URBAN DESIGN BRIEF

MARKETPLACE WEST

35 STOREY APARTMENT BUILDING
1034 MCGARRY TERRACE

Stantec has prepared the following response to recommendations received from the Urban Design Review Panel (UDRP) on 19 June 2023 following an informal presentation by the project team on 2 June 2023. Panel comments have been listed in the left column of the table below, whereas the project team’s response is provided in the right column.

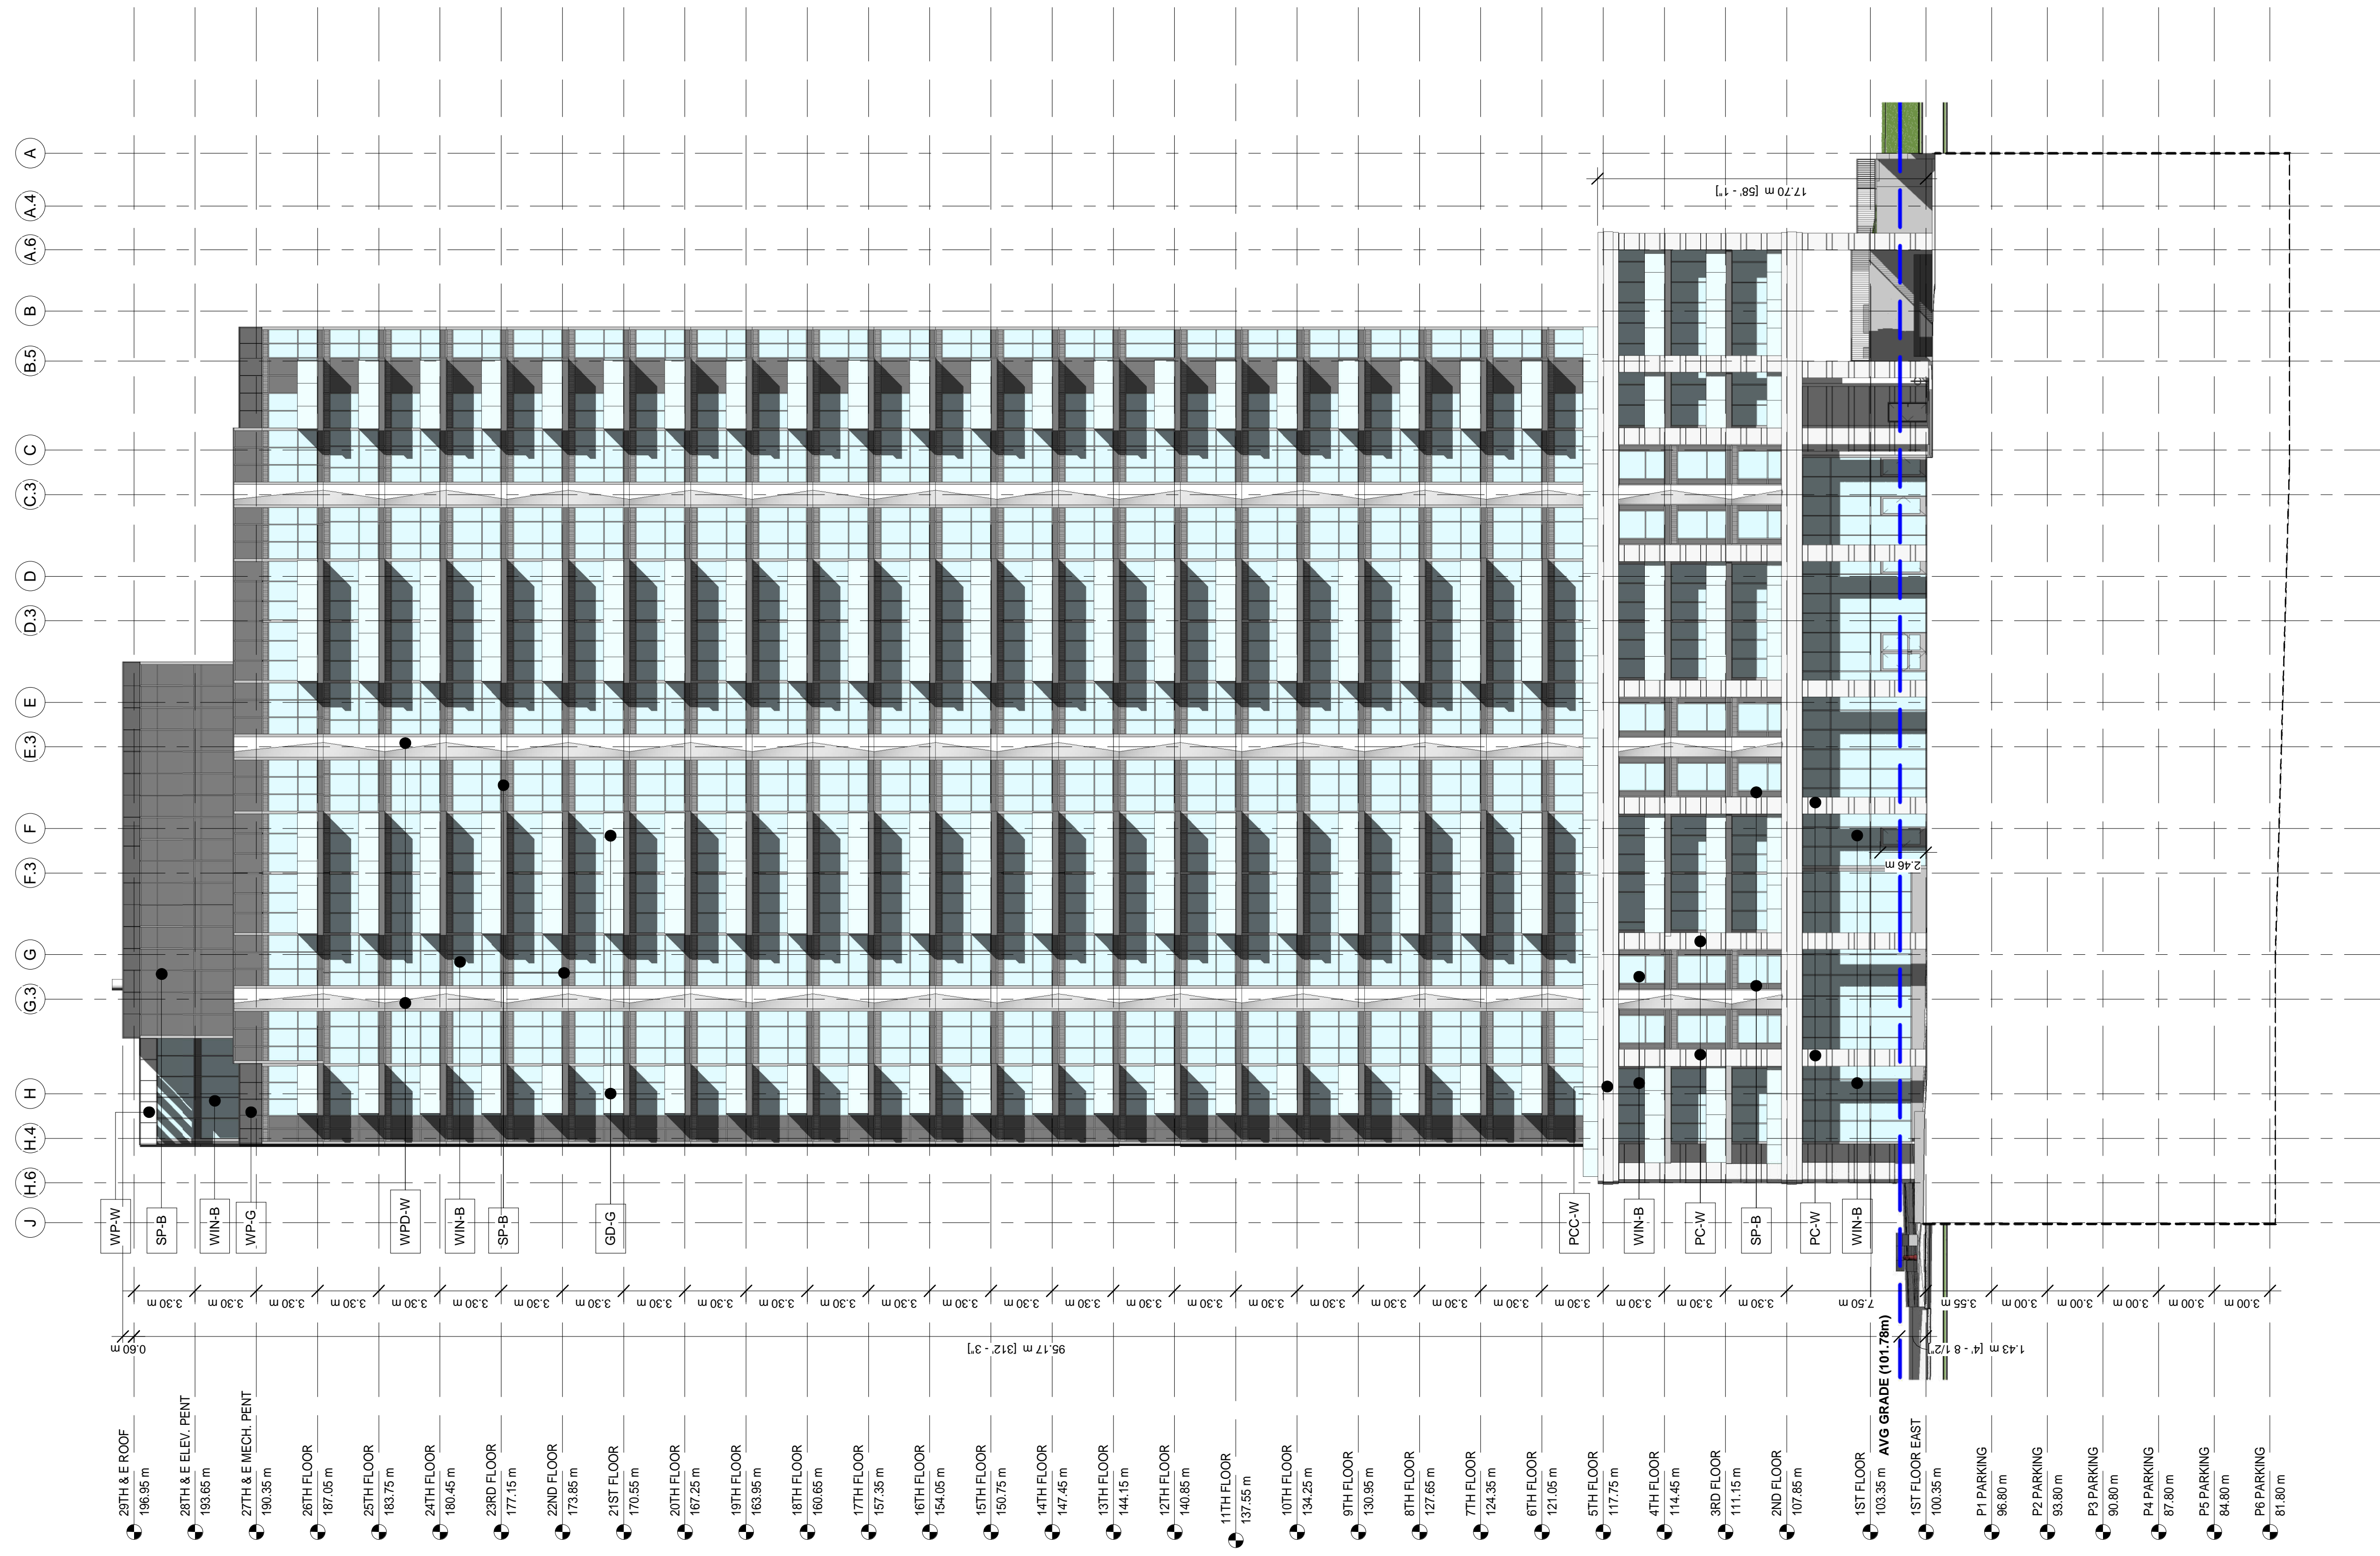
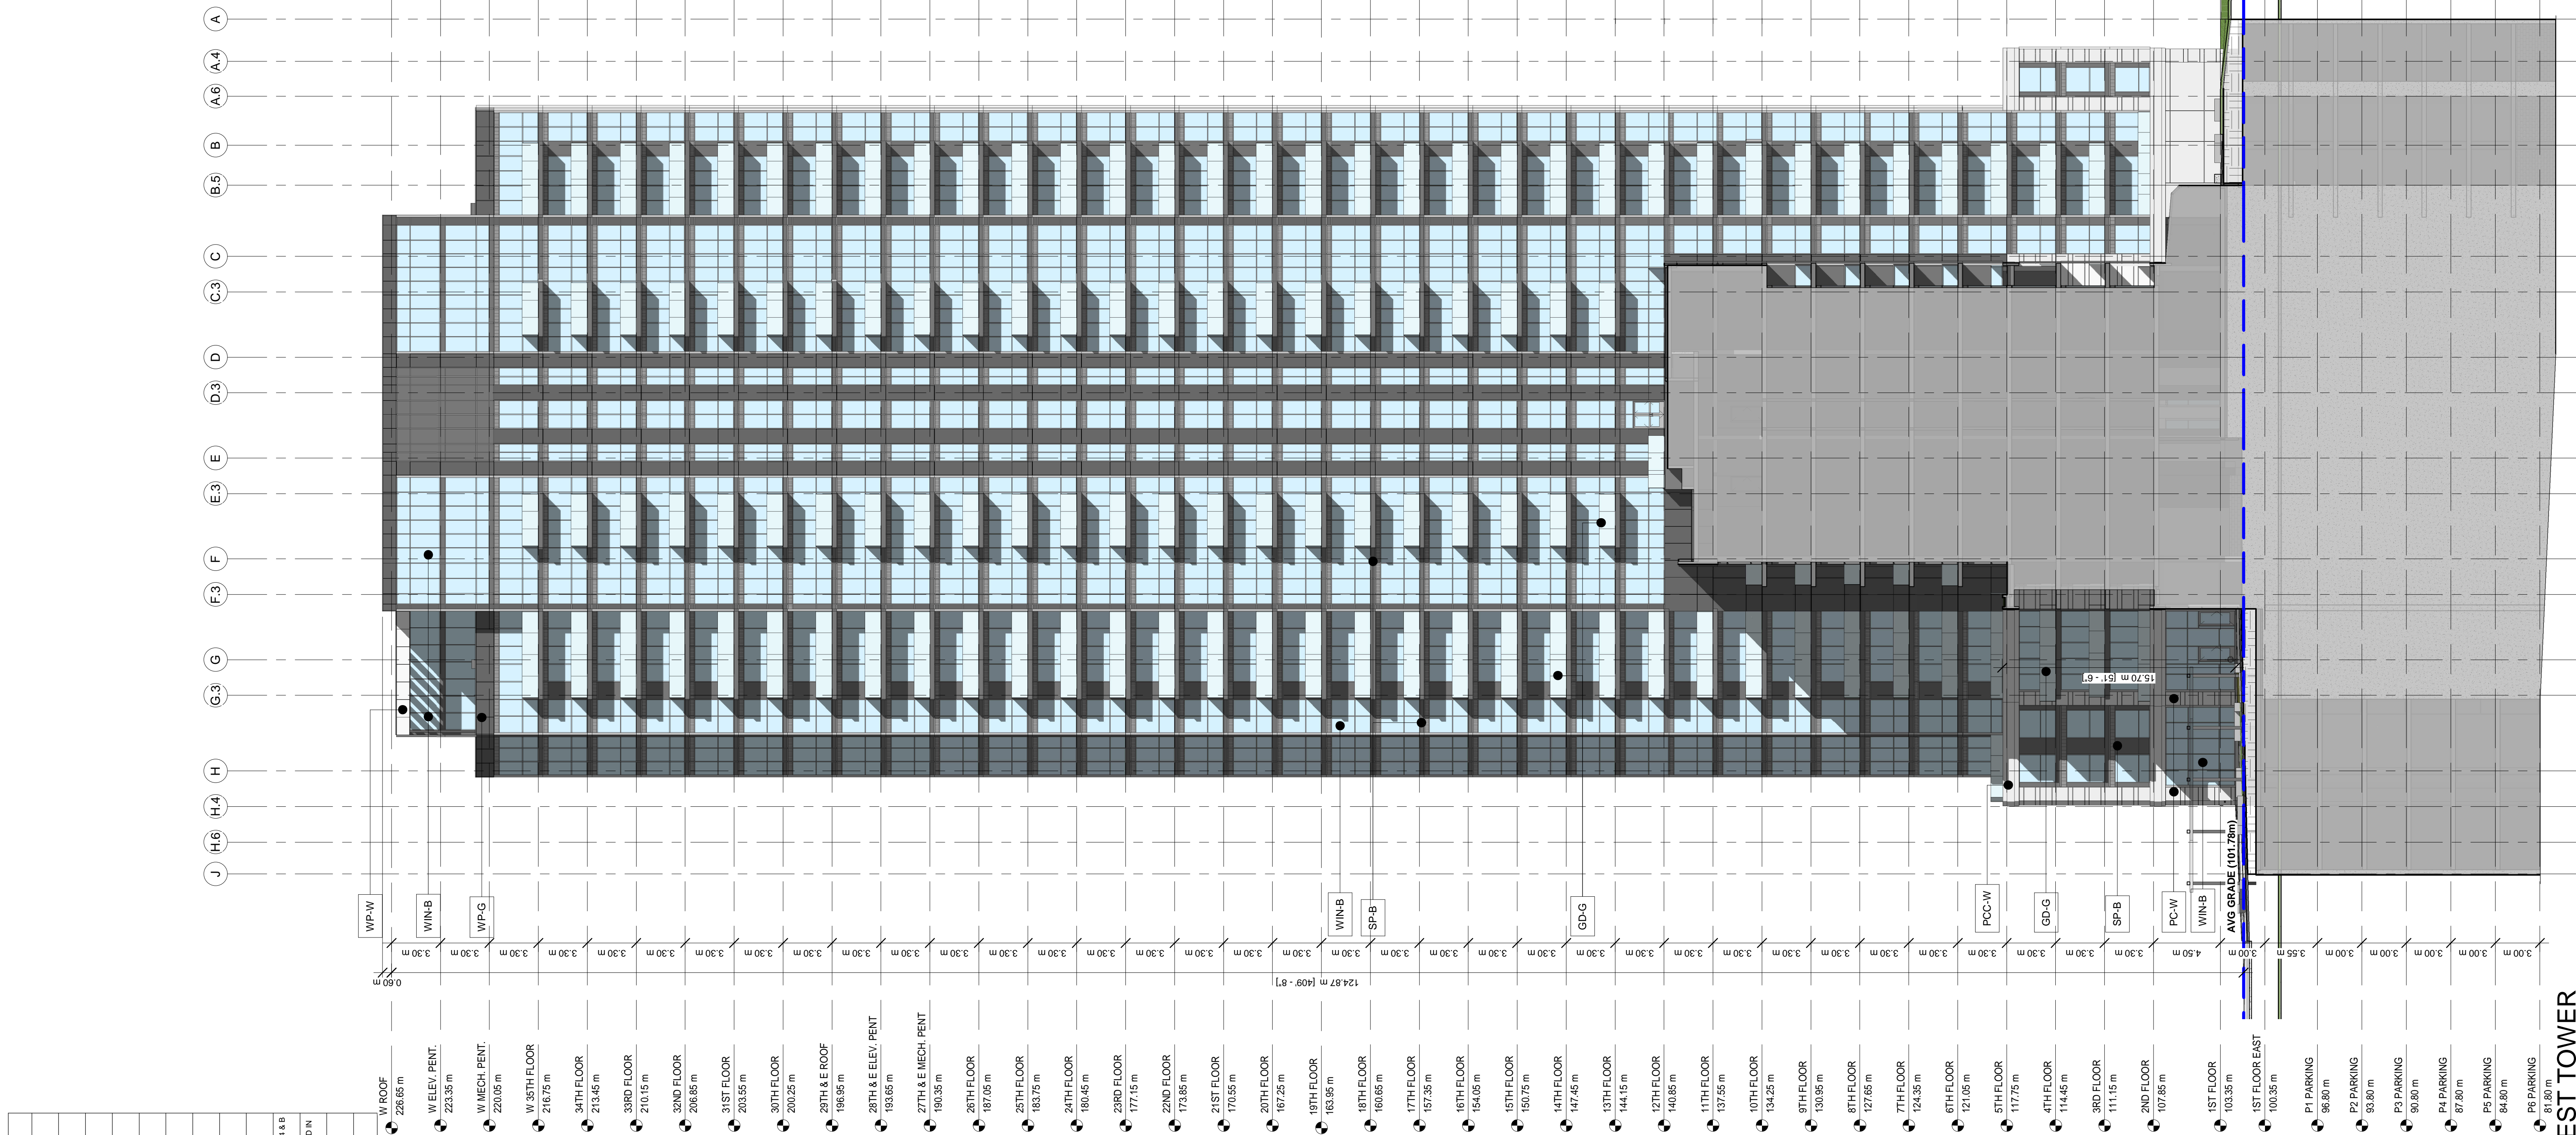
The Panel recommends stepping the towers back considerably along the street frontages

- Consider a minimum 3 metre step-back above the 4-storey podium
- Consider additional step-backs up the tower.

The Panel recommends staggering the heights of the towers to a more appropriate scale and transition from the surrounding context.

- Consider a 30-storey tower on the west side nearest to McGarry Terrace, and a shorter tower closer to 20-storeys on the east side

Step-backs have been provided from Marketplace Avenue and McGarry Terrace. Tower floorplates have been reduced to the extent feasible to increase tower separation distances and increase step-backs.

To ensure that there is variation in height between the two towers, it is proposed that the west tower be reduced to 35 storeys in height, whereas the east tower would be reduced to 26 storeys.
